Recommendation Report for Planning Permission for Works or Extension to a Dwelling

REF NO: LU/198/19/HH

LOCATION: 5 Rayden Close
Littlehampton
BN17 5QF

PROPOSAL: Demolition of existing conservatory and construction of new single storey side extension. Construction of single storey extension behind garage.

Ground Floor Plan

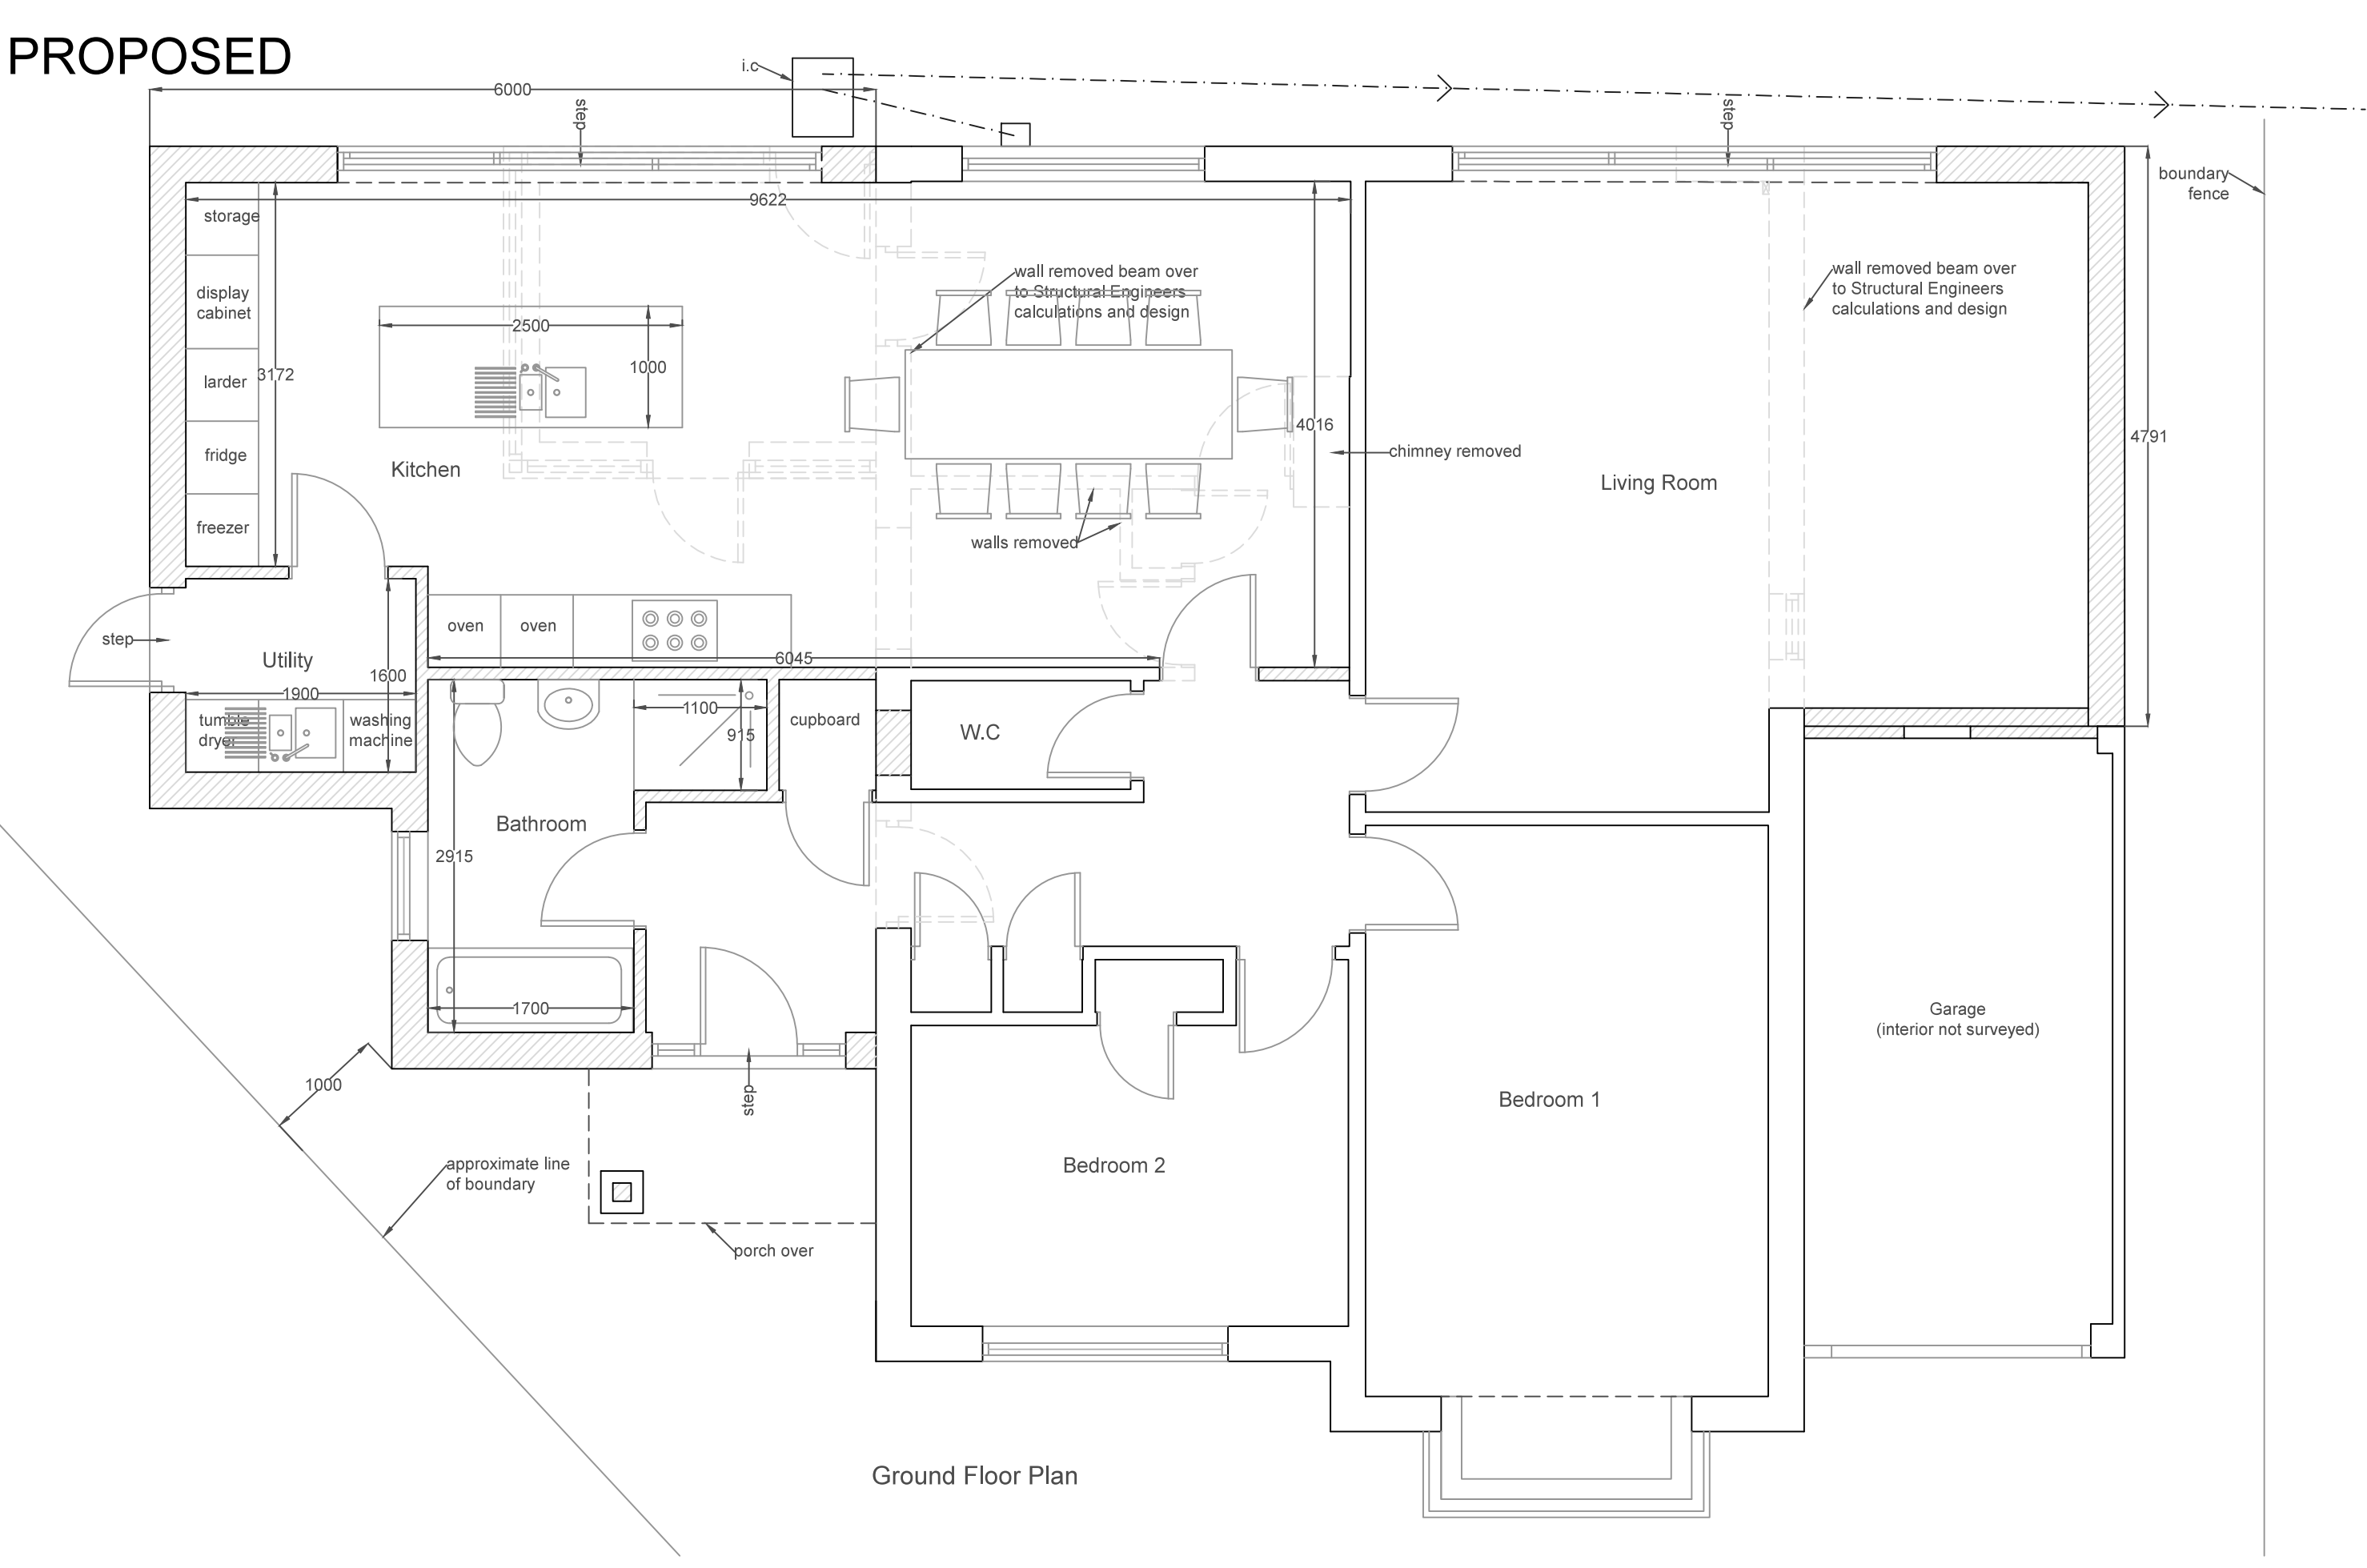
The side extension aspect of the application will be somewhat visible from the street scene. The proposed side extension will measure approximately 9.3m in length, 6.3m in width and be built to a proposed height of 3.45m and an eaves height of 2.4m. The rear extension will not be visible from the street scene, it will measure approximately 5m in length, 3.3m in width and be built to a height of 3.45m and an eaves height of 2.4m.

The proposed side and rear extension will be constructed from materials which will match in design and appearance those used in the construction of the original dwellinghouse and therefore is considered to appear well integrated and subservient to the host dwelling in accordance with policies D DM1 and D DM4 of the Arun Local Plan and policy 1 of the Littlehampton Neighbourhood Plan.

Elevations (1:100)

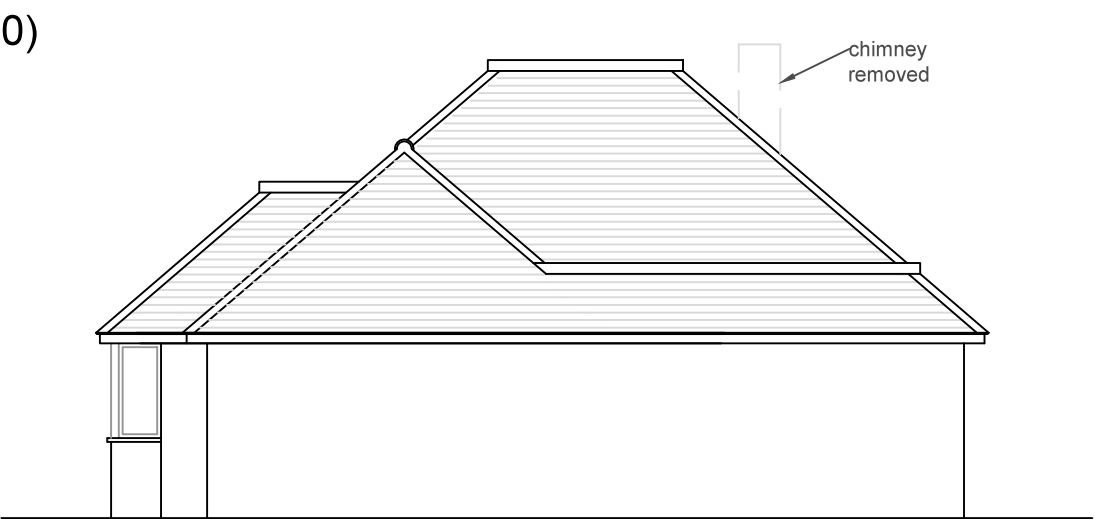
The proposed rear extension will be located approximately 1m from the Northern boundary and 13.3m from the Western boundary. The rear extension will feature two sets of glass doors and one set of French windows on the Western elevation, there is a separation distance of approximately 13.3m from the doors to the rear boundary of the property. The proposed side extension has one door and one window. Given the distance from the proposals to the rear boundary the proposals are not considered to give rise to any unacceptably adverse overlooking of neighbouring properties.
